Rezoning Transportation Analysis

Petition Number: 2023-030

E1From: Jake Carpenter, PE
Jacob.carpenter@charlottenc.gov
980-221-5675

RZ-1.0

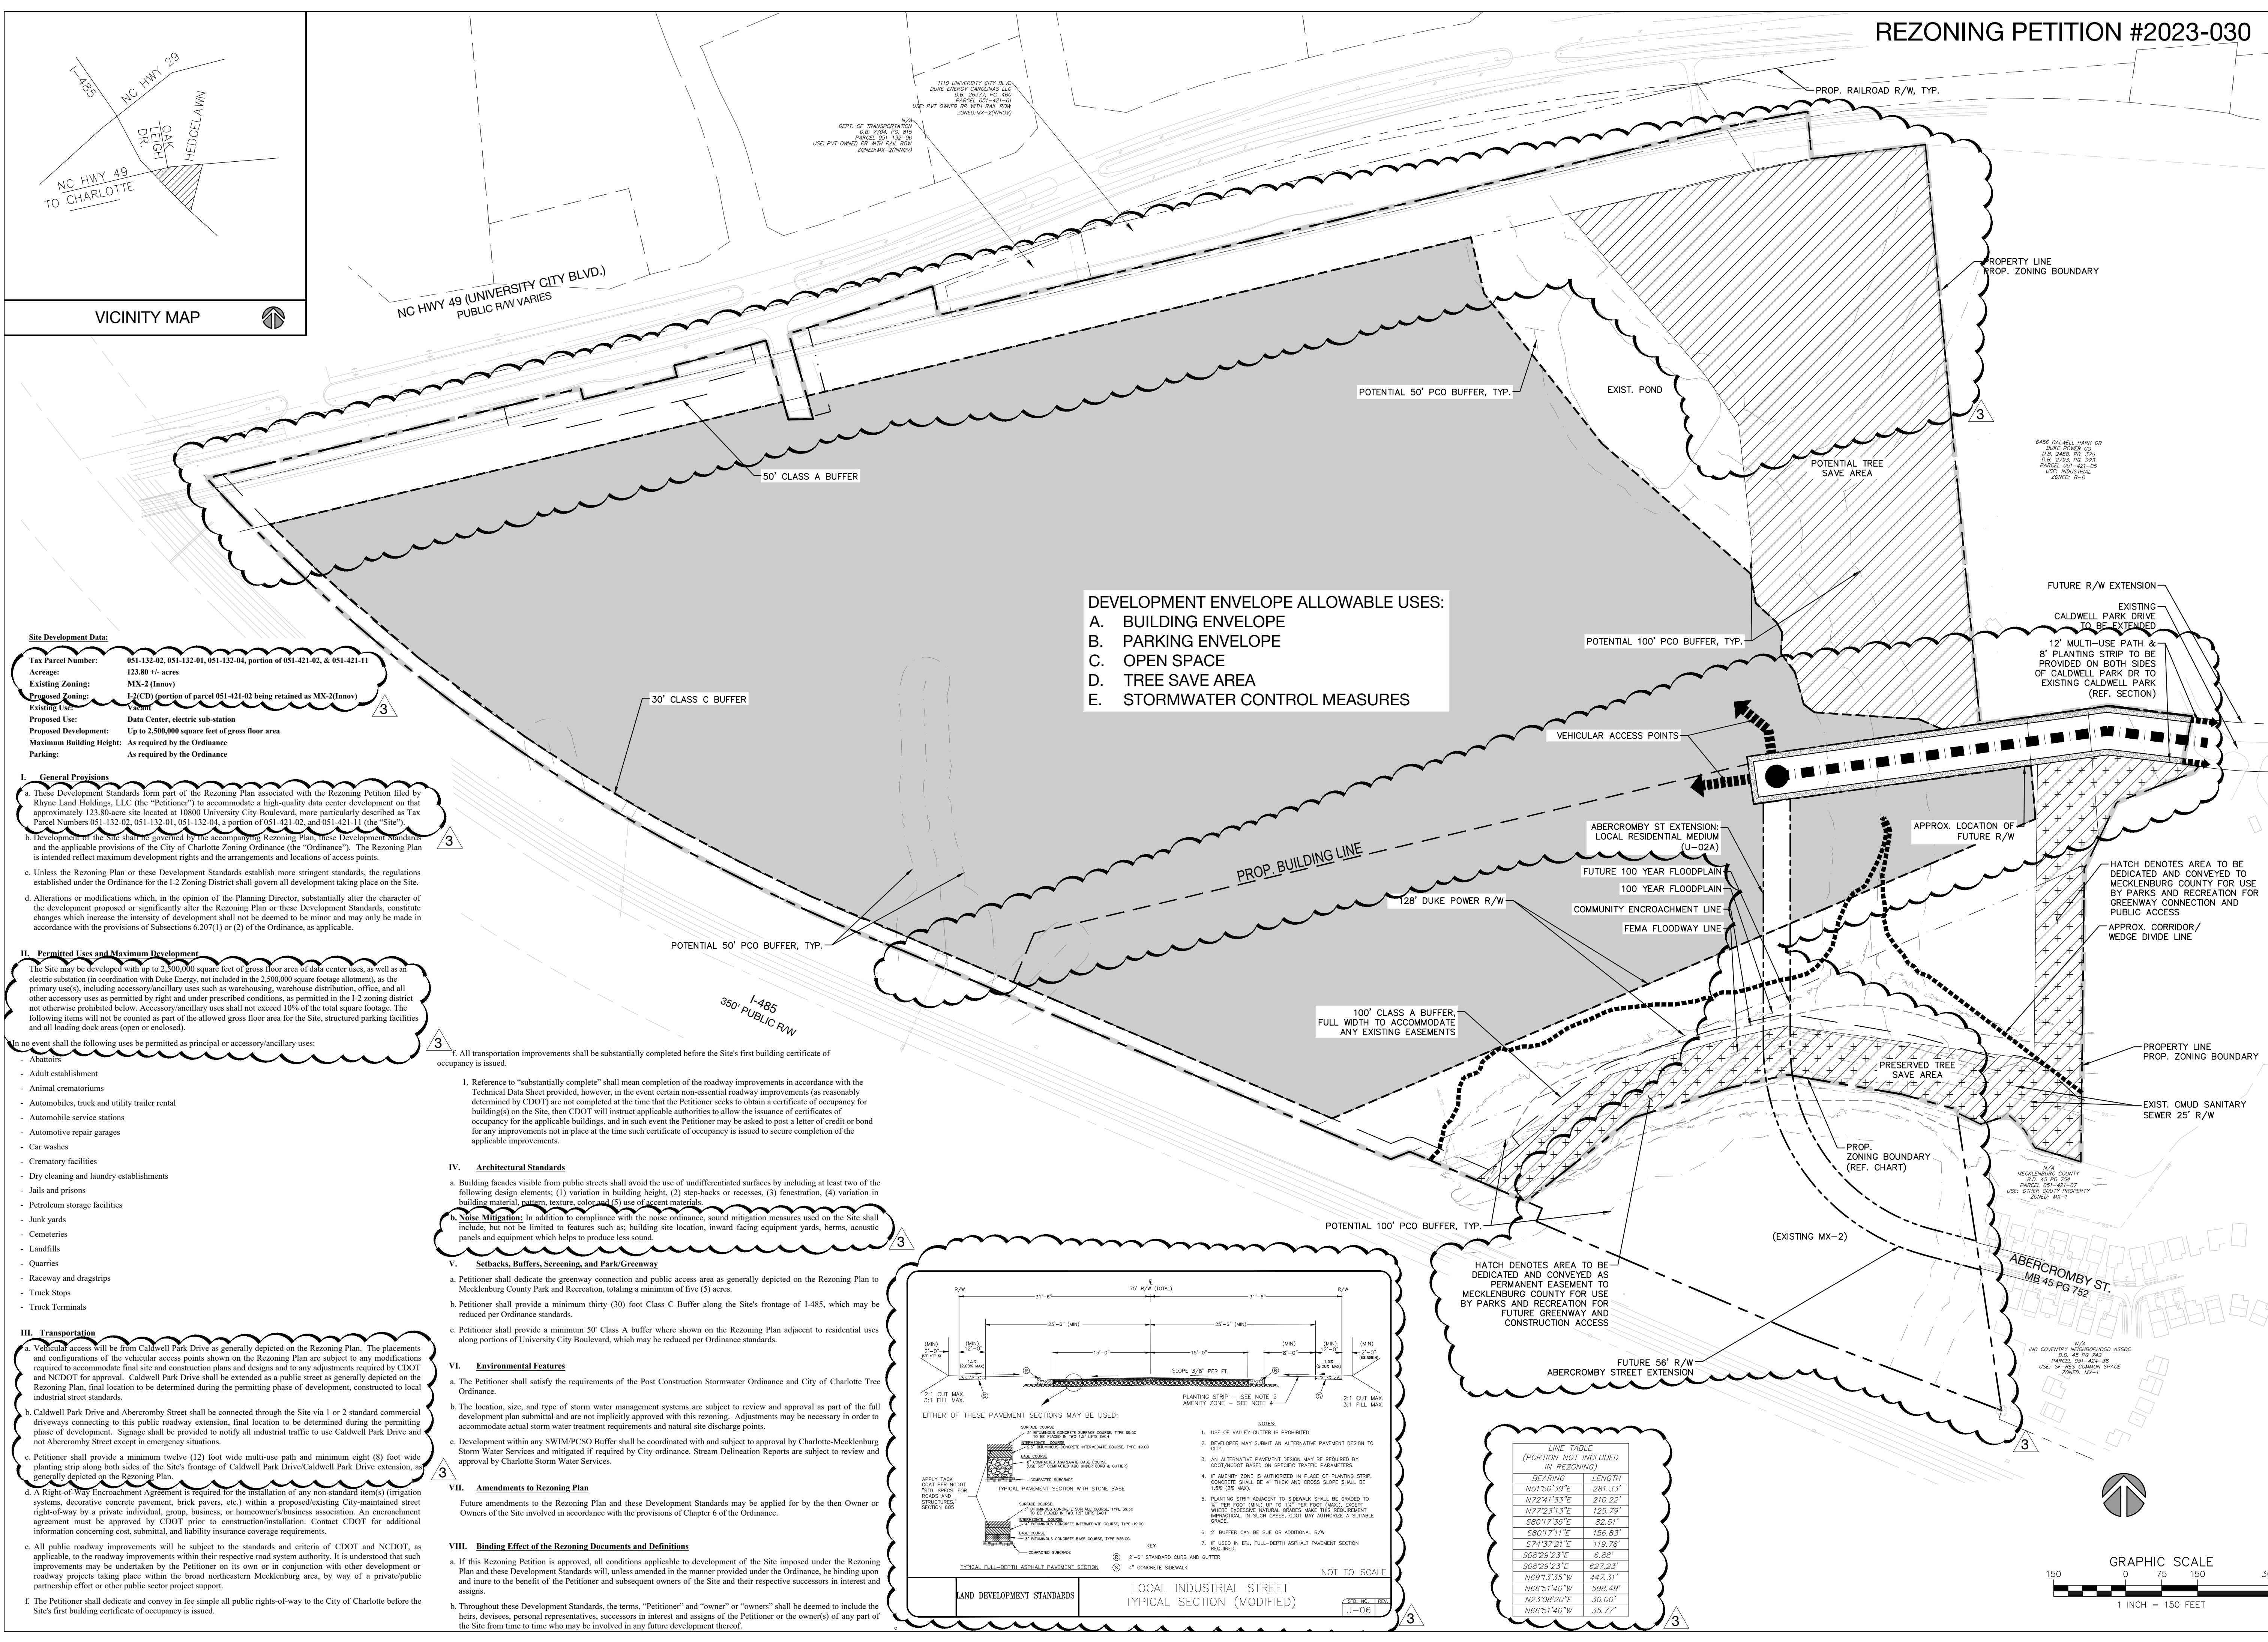
- NEW COMMENT 07.28.2023:** Revise site plan and conditional notes to connect Abercromby Street to Caldwell Park Drive. Site access shall be via 1 or 2 standard commercial driveways connecting to this roadway extension. Site plan shall commit to installing signage for all industrial traffic to use Caldwell Park Drive and not Abercromby Street.

5. Add conditional note that petitioner shall construct bicycle facilities by installing a 12' multi-use path with an 8' minimum planting strip along Caldwell Park Drive. The proposed multiuse path should be extended along the southern side of Caldwell Park Drive to the northwest corner of Parcel ID 05114117 owned by Mecklenburg County.

Clarifying Comment 6.21.2023: Label and dimension streetscape elements (12' multi-used path and 8' planting strip) along Caldwell Park Drive/Caldwell Park Drive extension.

Clarifying Comment 7.28.2023: 12-foot multi-use path shall be placed on both sides of the Caldwell Park Drive extension.
